**RE: Coors and Central – 100 Coors Blvd NW**  
**Conceptual Grading Plan**  
**Engineer's Stamp Date: No Stamp Date**  
**Hydrology File: K10D017**

Based upon the information provided in your submittal received 12/06/17, the Conceptual Grading Plan **is not** approved for Site Plan for Building Permit. The following comments need to be addressed for approval of the above referenced project:

A1 GRADING AND DRAINAGE PLAN
SCALE: 1"=20'

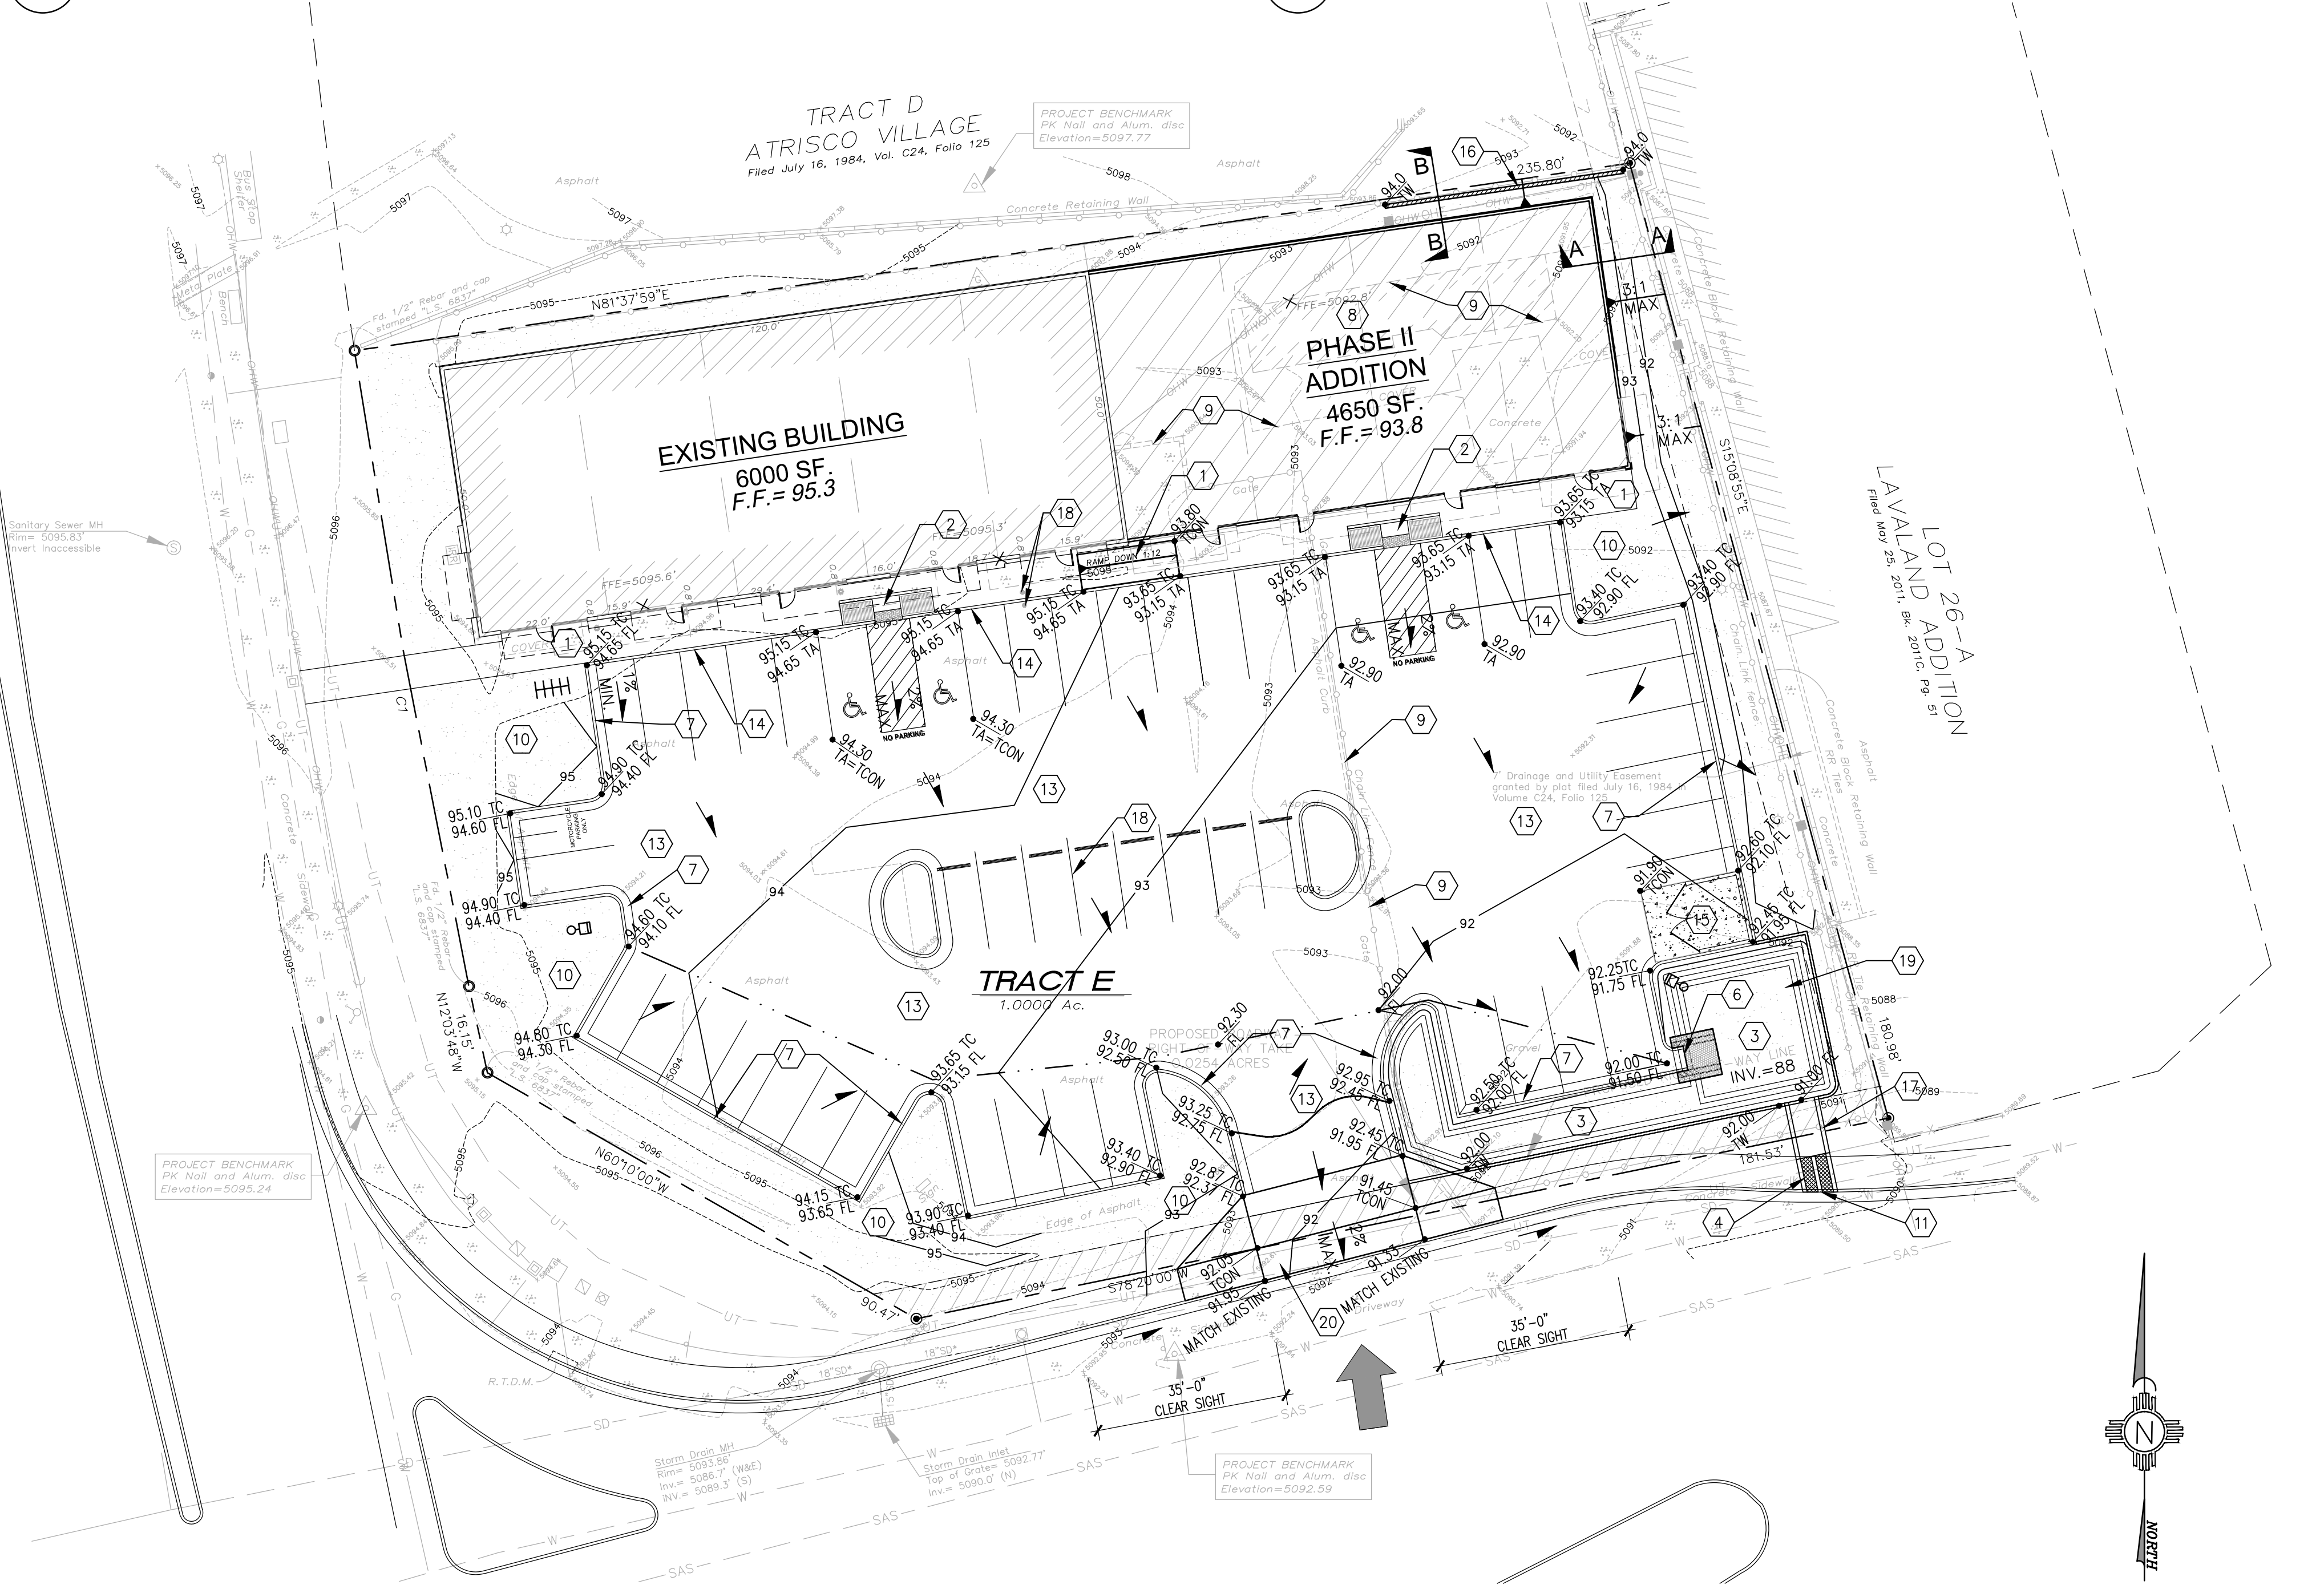
3. Please add the property line in both Section A-A and Section B-B.
4. Please also show the retaining wall footer in both Section A-A and Section B-B.
5. Per DPM Ch. 22.5.B, grading and construction of retaining walls at or near the property line must demonstrate that the adjacent property is not damaged or its use constrained. Any such encroachment by the wall or grading must be accompanied by written permission of both landowners.

A1 CONCEPTUAL GRADING AND DRAINAGE PLAN
SCALE: 1"=20'

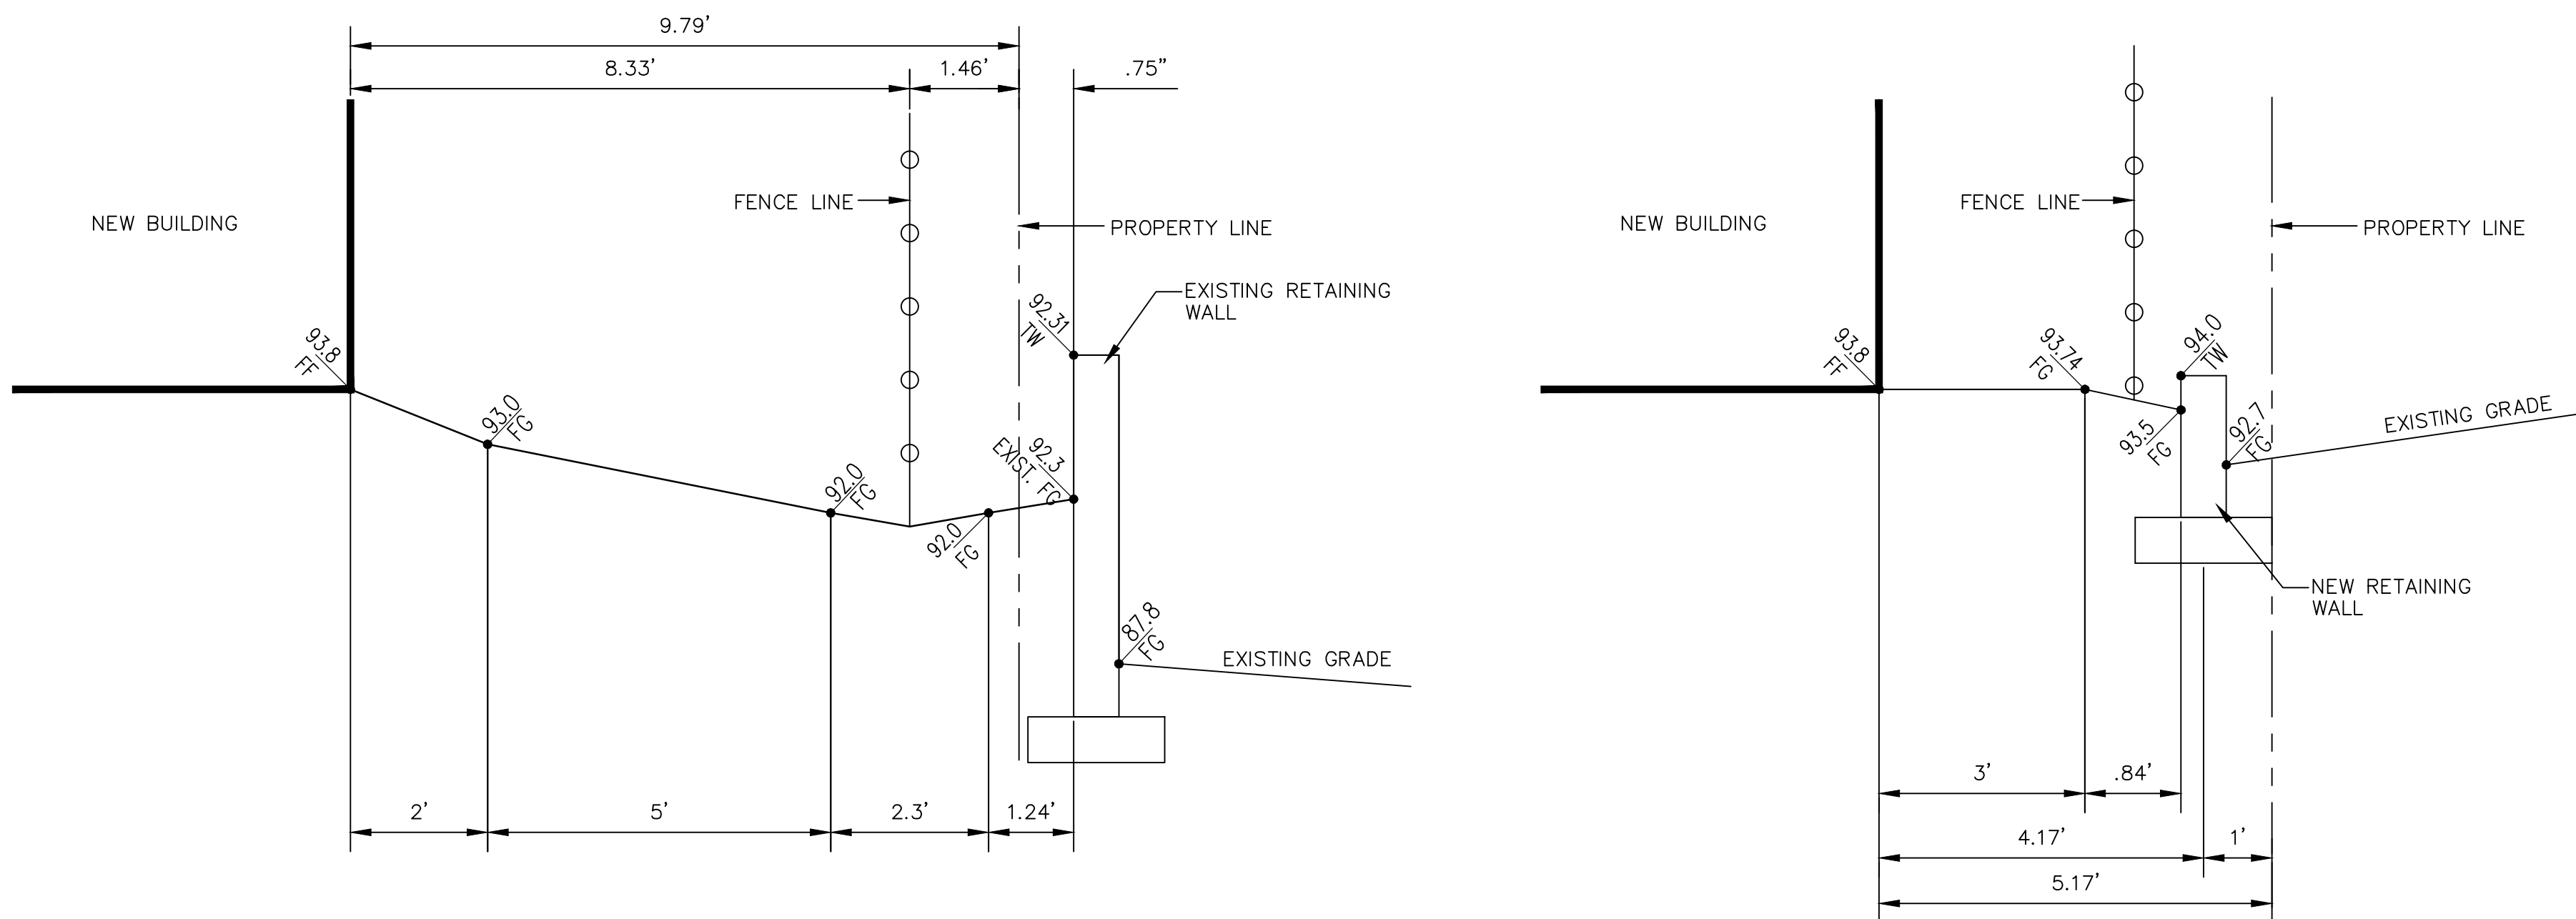
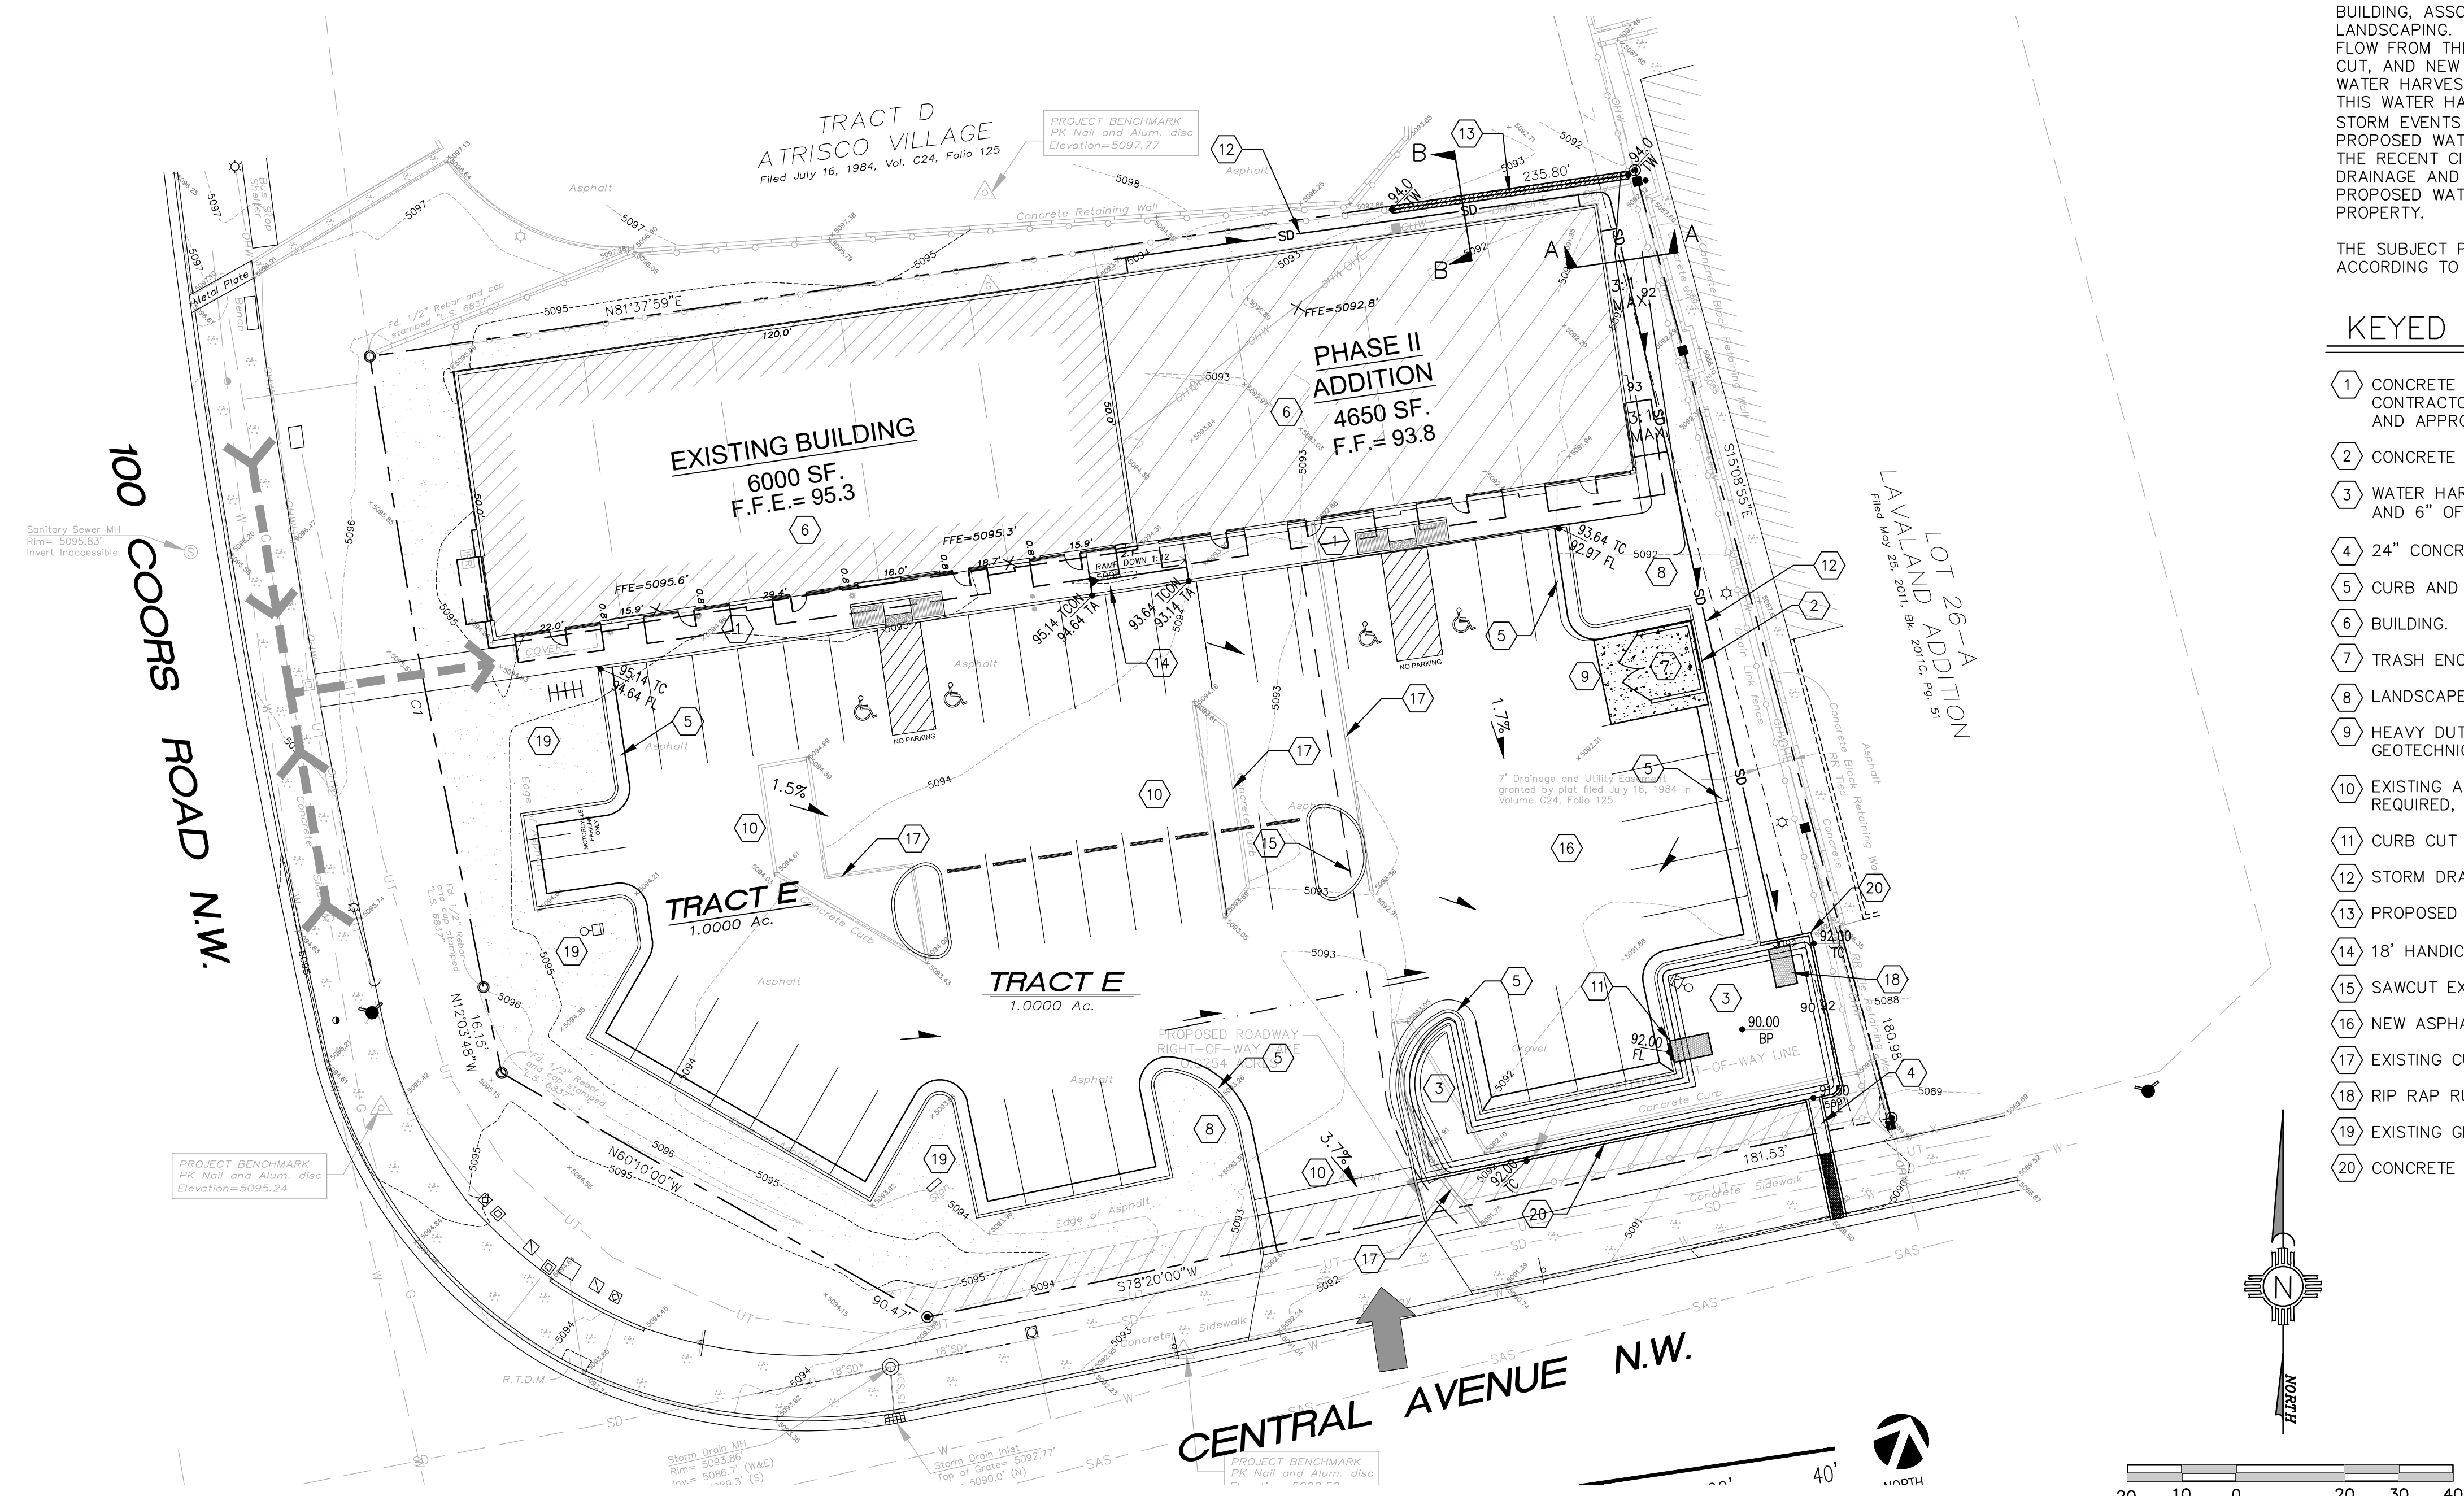
1. Please provide the FIRM Map and flood plain note with effective date.
2. Please provide a vicinity map showing the location of the site. Typically this is the Zone Atlas. This can be downloaded in pdf format from the City of Albuquerque's website.

6. Per Transportation's DRB comments on December 6, 2017, the overall site plan will have some changes and some will affect the drainage. Please insure that the Conceptual Grading Plan matches the Site Plan for Building Permit.
